**Consultation Response from KC,
Ecology Unit**

2025/90889 Former Combs Hostel, Hall Lane, Thornhill, Dewsbury, WF12 0PL

Demolition of existing hostel and erection of residential development comprising 34 dwellings

Date Responded: 29/07/2026

Preliminary drainage layout if SUDs are unsuitable following site investigation for approval only.

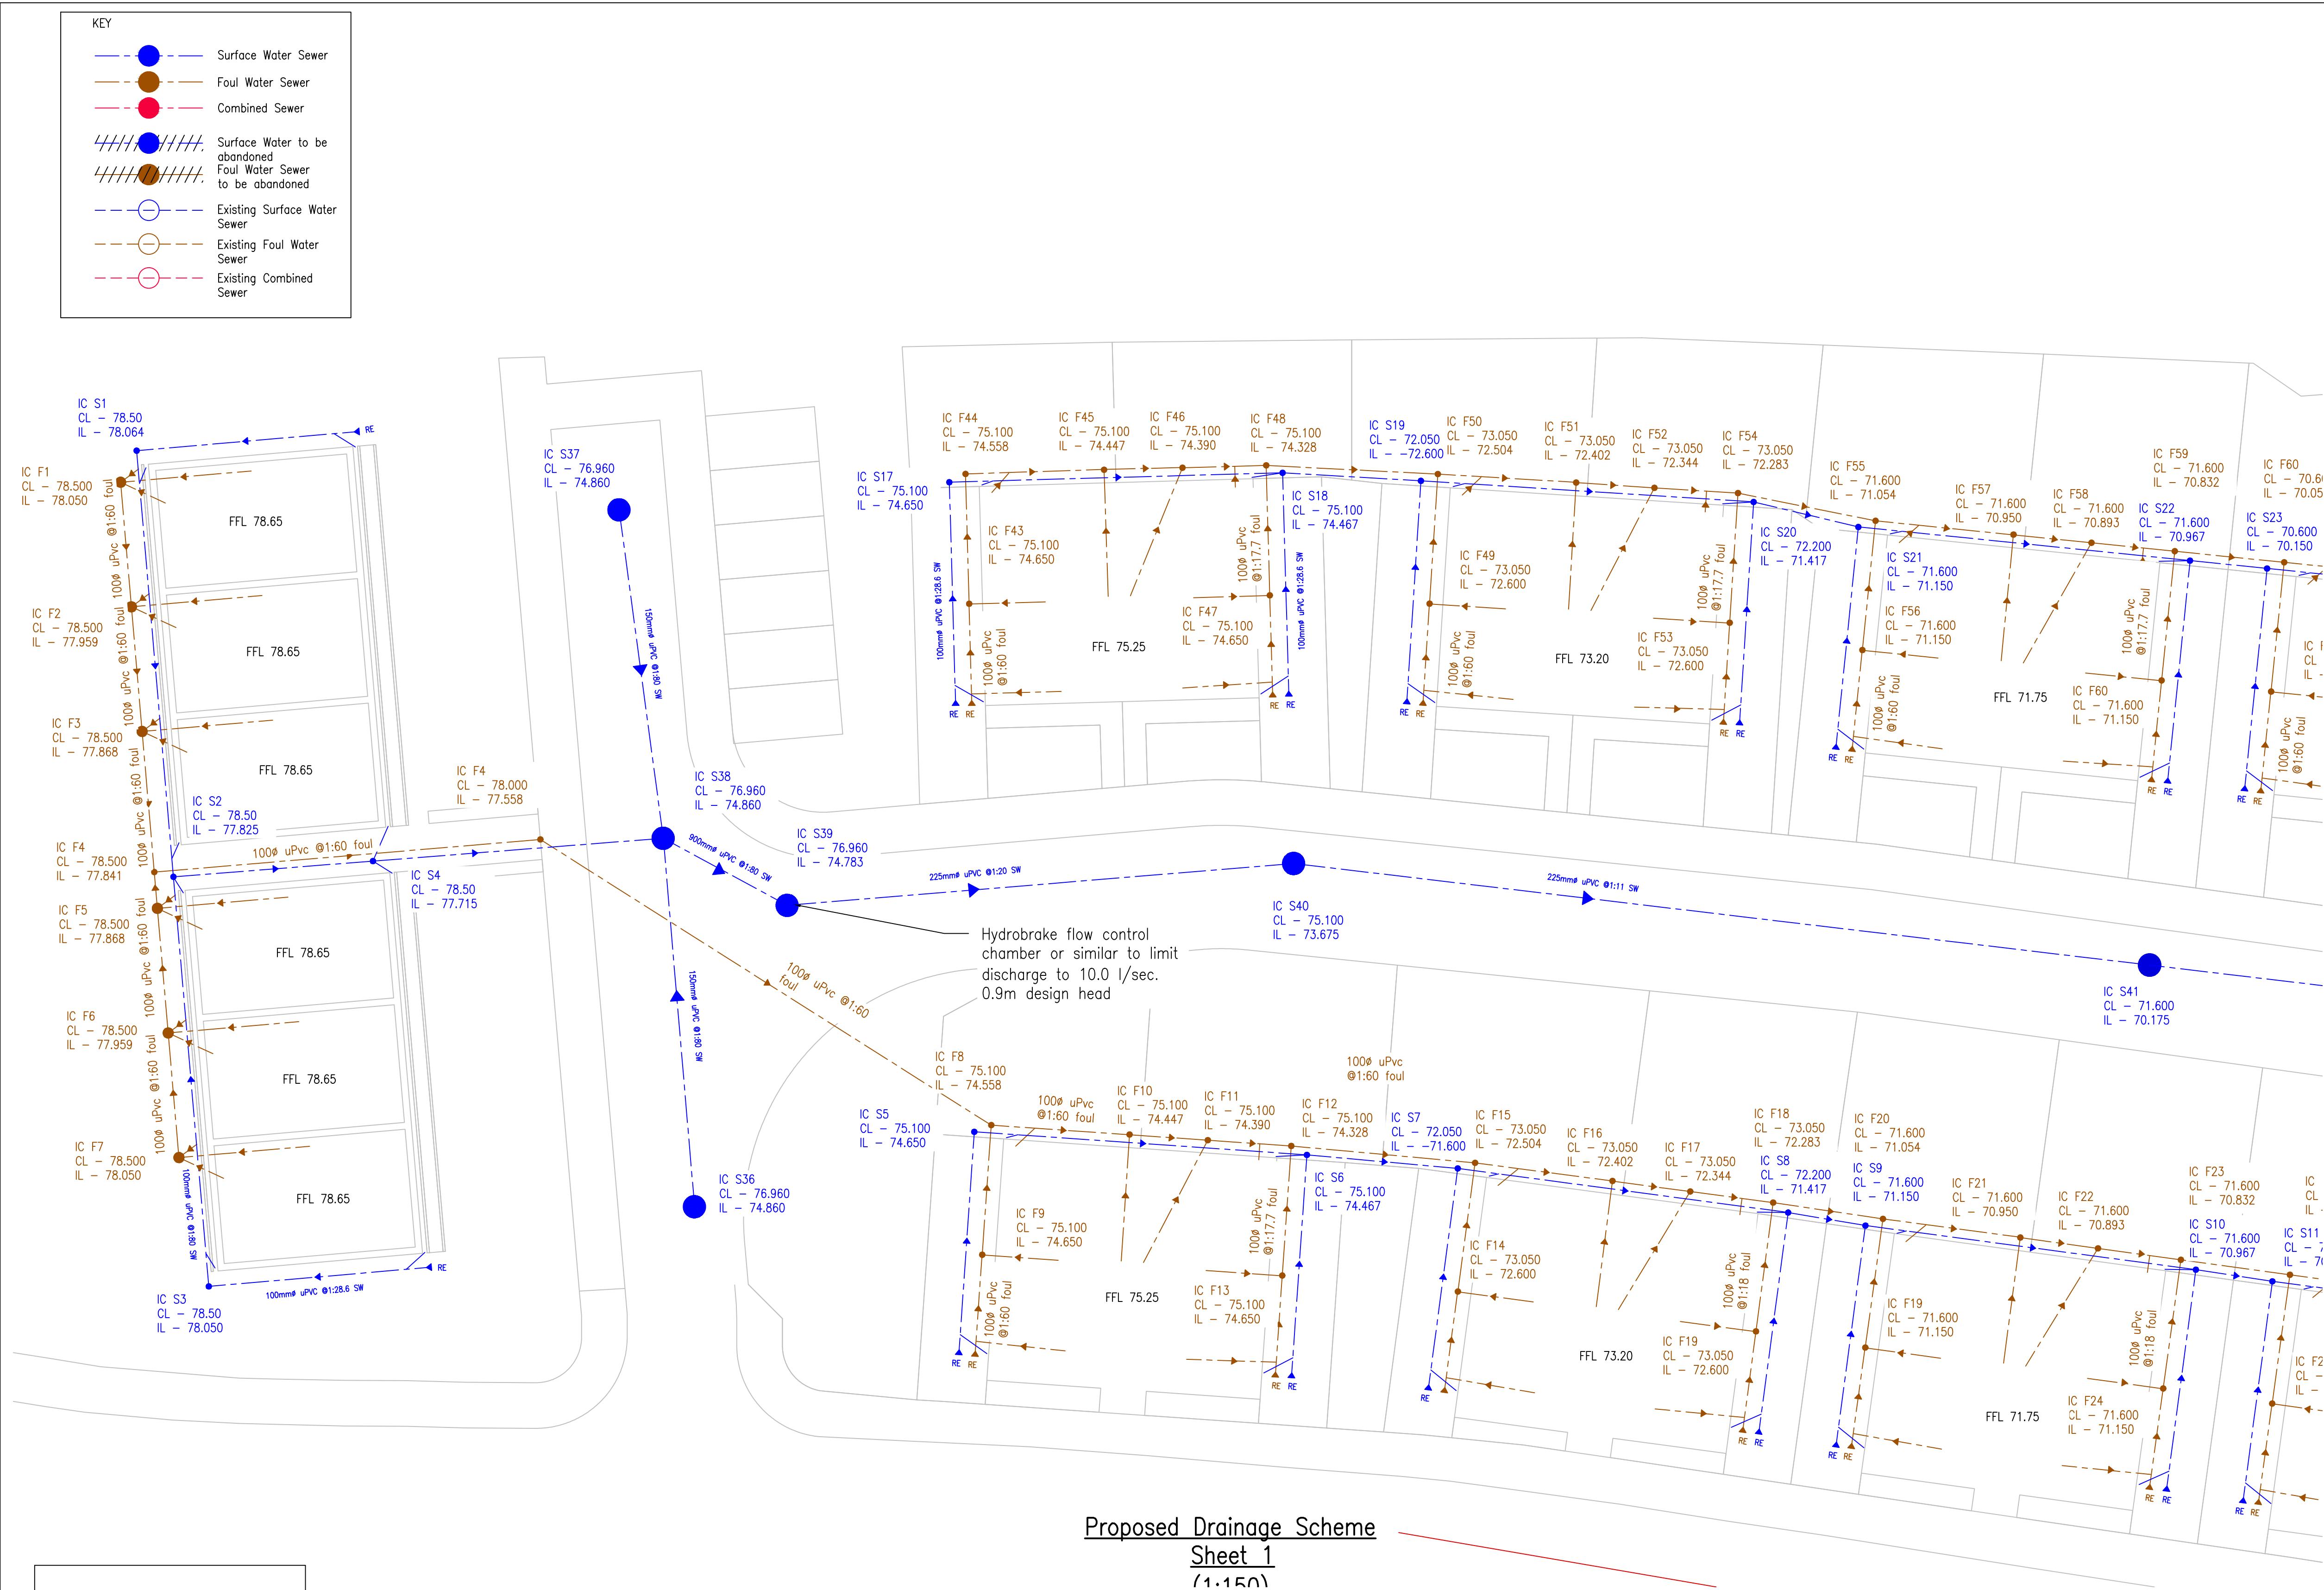
The comments and recommended conditions from the previous KC Ecology comments (dated March 2026) still apply. I note that updated information on a SuDS or retention pond hasn't been provided.
